Planning Act 2008 – Section 88 and the Infrastructure Planning (Examination Procedure) Rules 2010 – Deadline 5: Post Hearing submission of oral case for Issue Specific Hearing 7 (Biodiversity and Ecology), Part 1 and 2.

Application by NNB Generation Company (SZC) Limited for an Order Granting Development Consent for the Sizewell C Project

Appendix A: Environment Agency summary of oral case for ISH7 – Part 1: Biodiversity and Ecology

A SECTION
SCALE 1:500

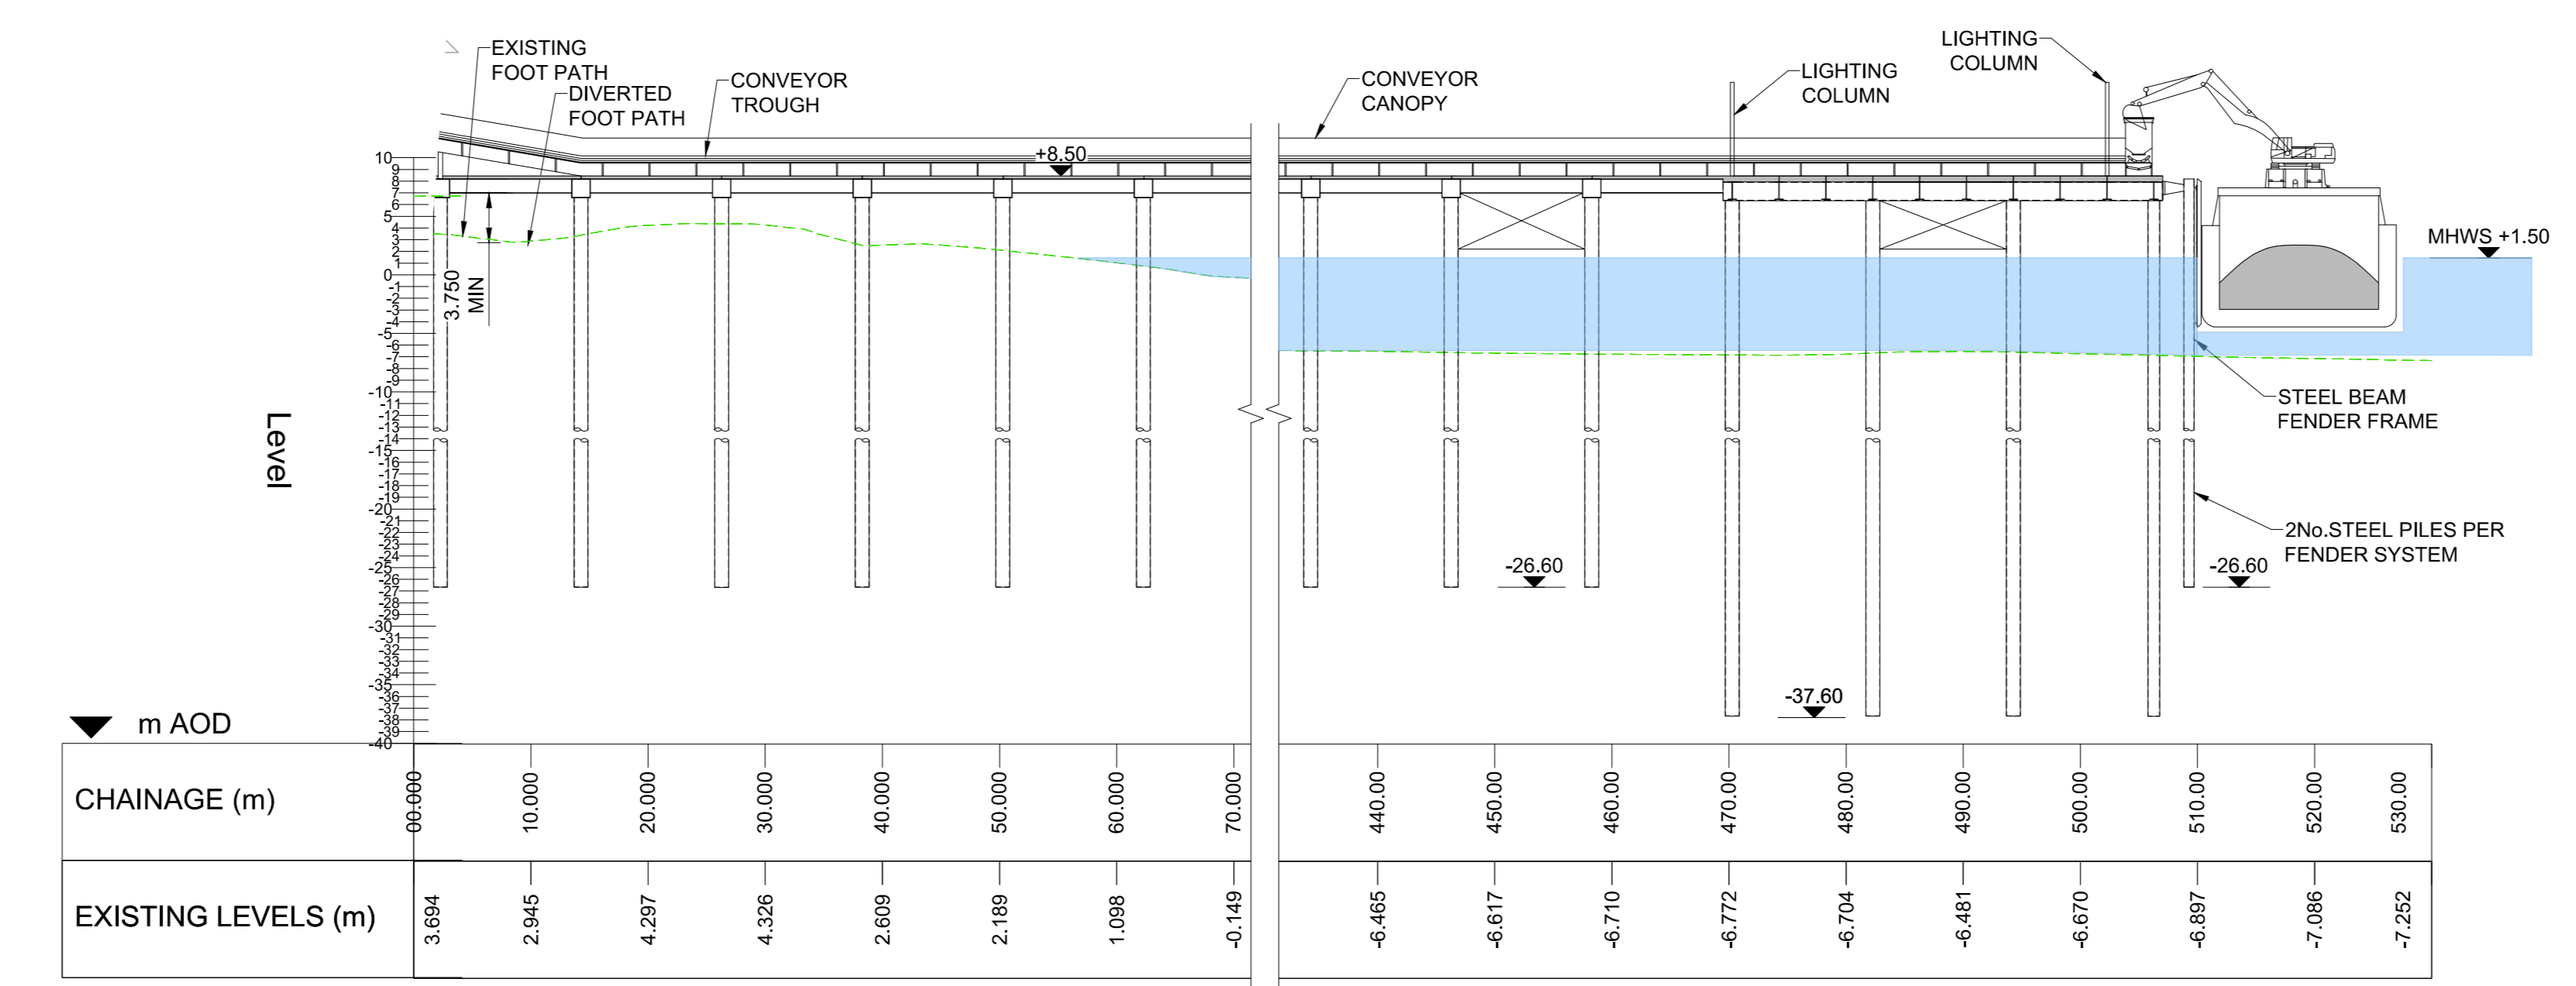
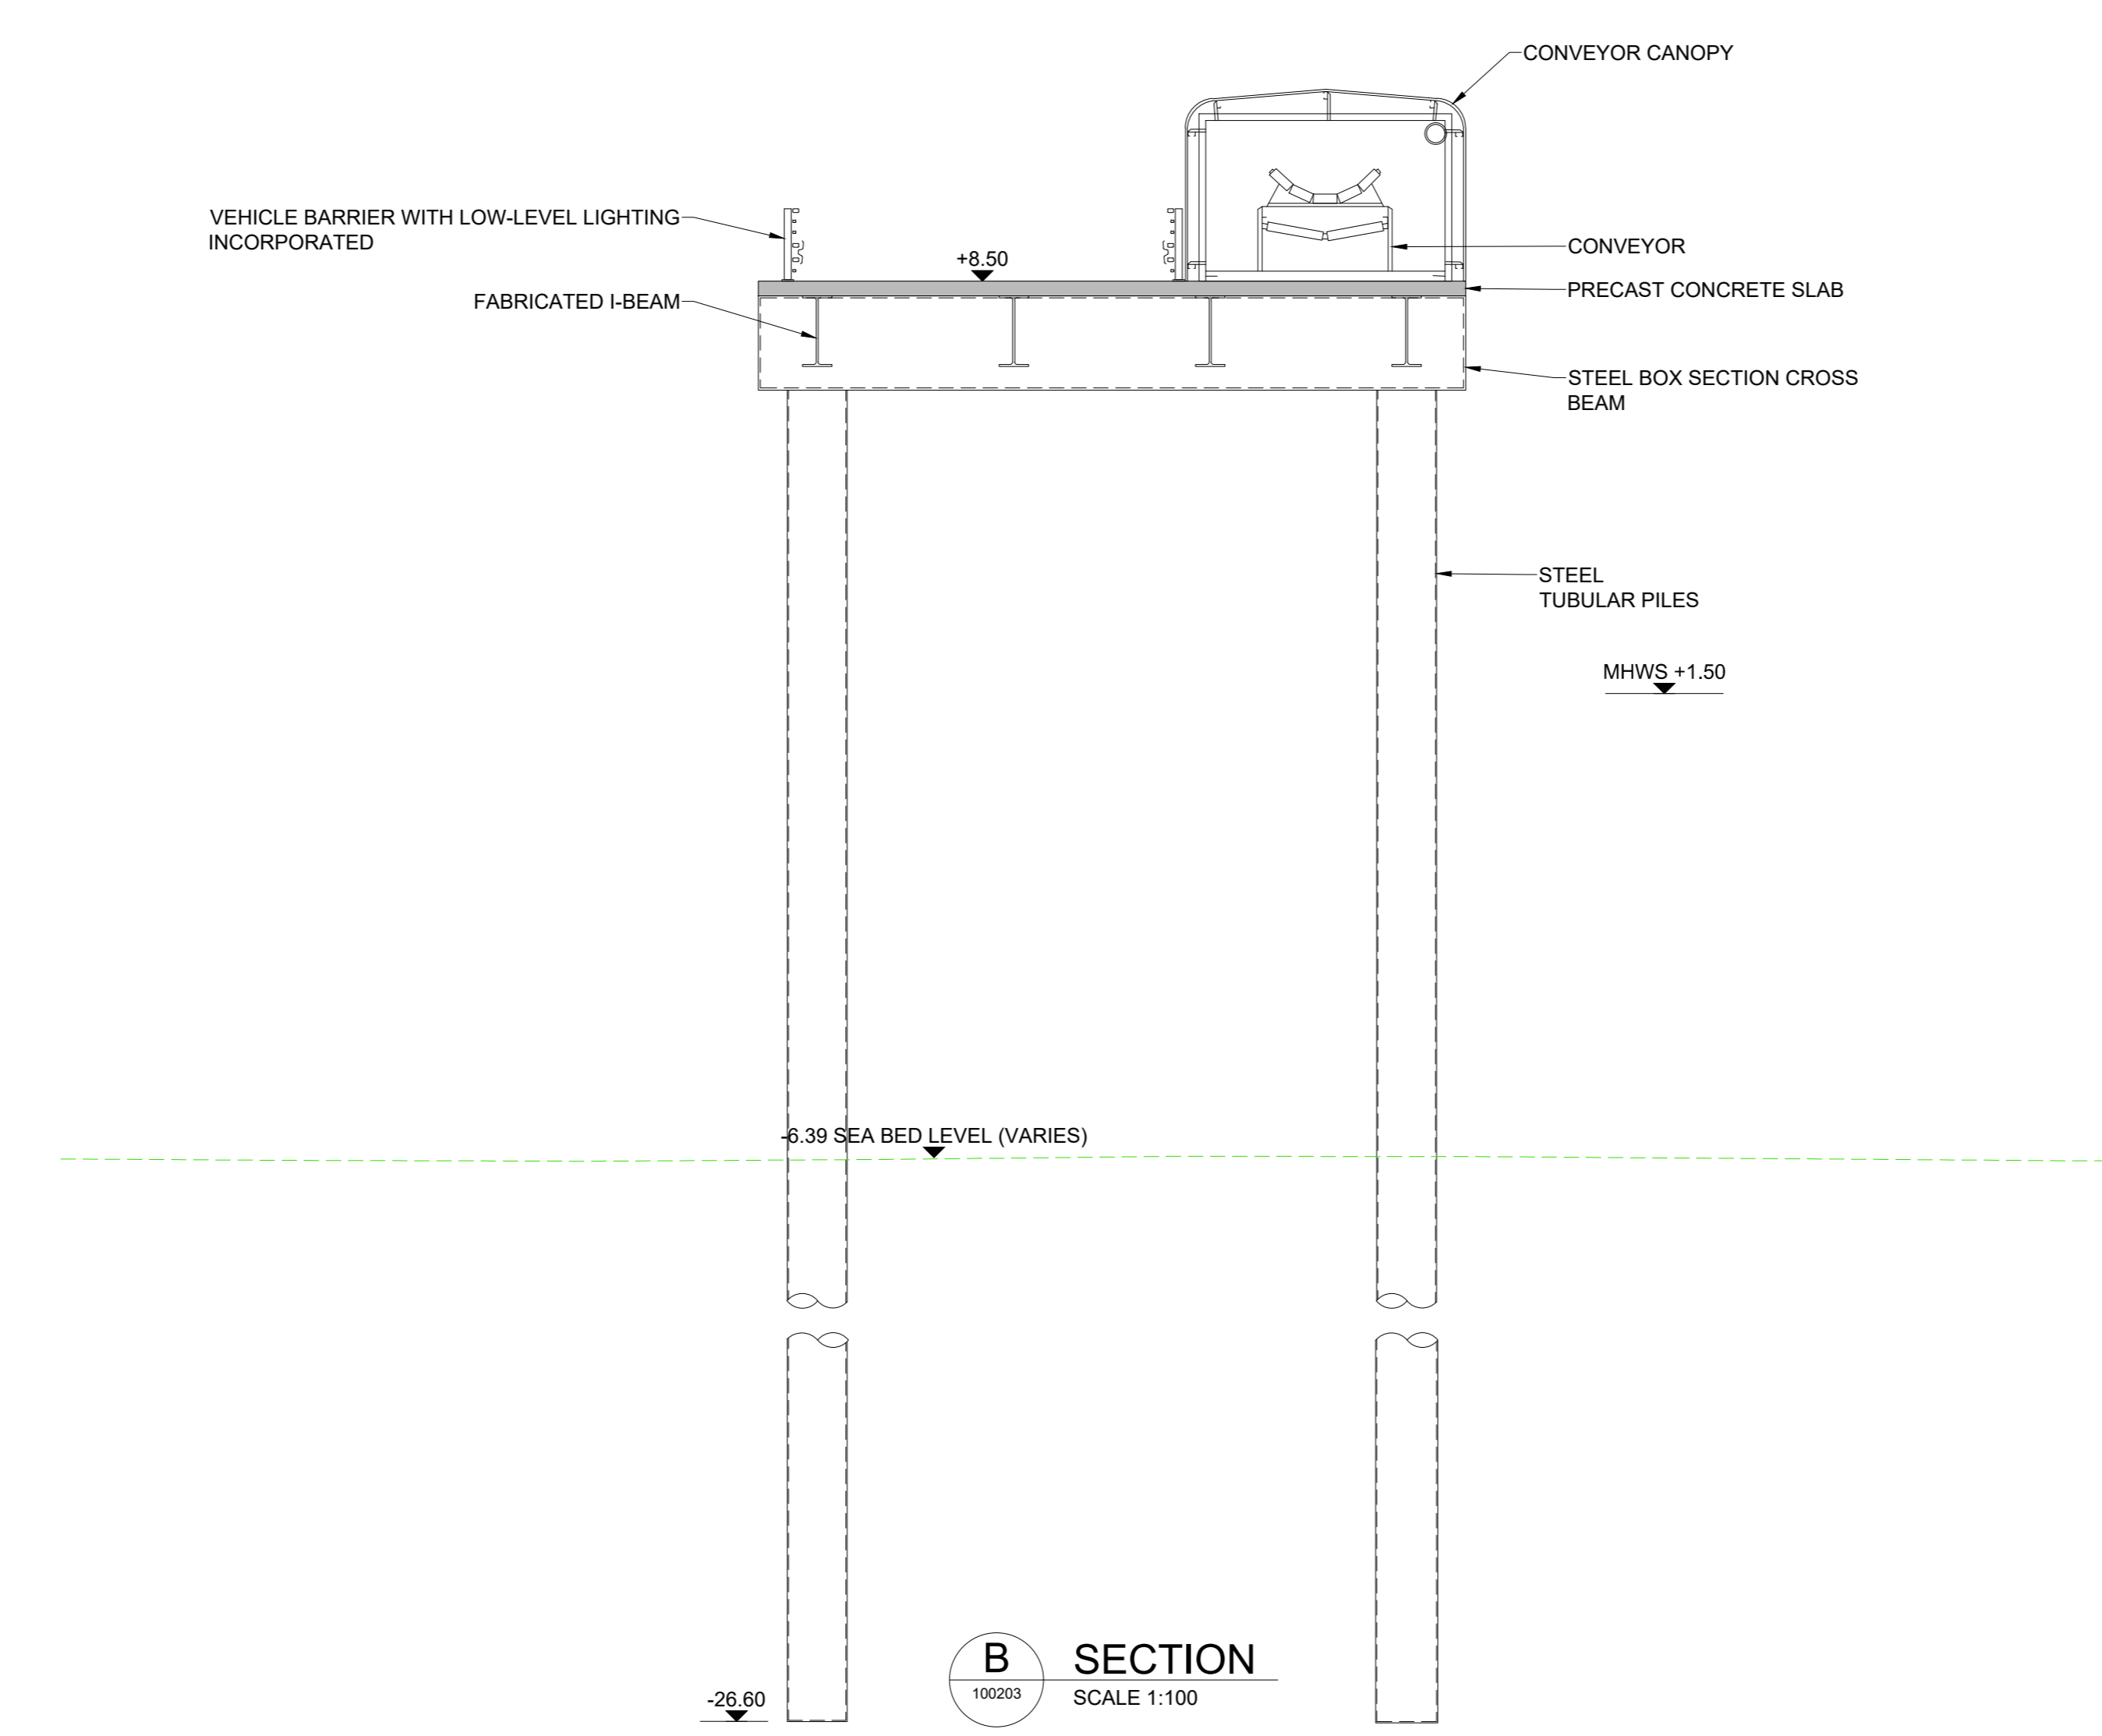
i. the SSSI crossing	<p>SSSI crossing:</p> <p>The current proposed design of the SSSI crossing would prevent the upstream and downstream migration of numerous polarotactic invertebrate species (which navigate using polarized light reflected from the water's surface) either side of the crossing approximately halfway along the river, and its associated SSSI designated habitat. This will lead to fragmentation of sensitive habitats and the isolation of species populations which could lead to a deterioration under the Water Environment Regulations 2017 (WFD) and would require a regulation 19 exemption under those regulations. It could also prevent the movement of fish along the watercourse.</p> <p>The proposed design optimisation of increasing the soffit height of the crossing to >6m and reducing the width of the crossing to 15m after the construction period, as described by the Applicant in the response to our written representations is welcome. We await submission of the detailed designs and timeframes for each phase of the crossing at deadline 5. We will then determine if the risk of deterioration to invertebrates has been reduced to an acceptable level.</p> <p>The triple span bridge design remains our preferred option as it would further reduce impacts to the ecology of the area including invertebrates, and it would have the minimal land take from the SSSI.</p>
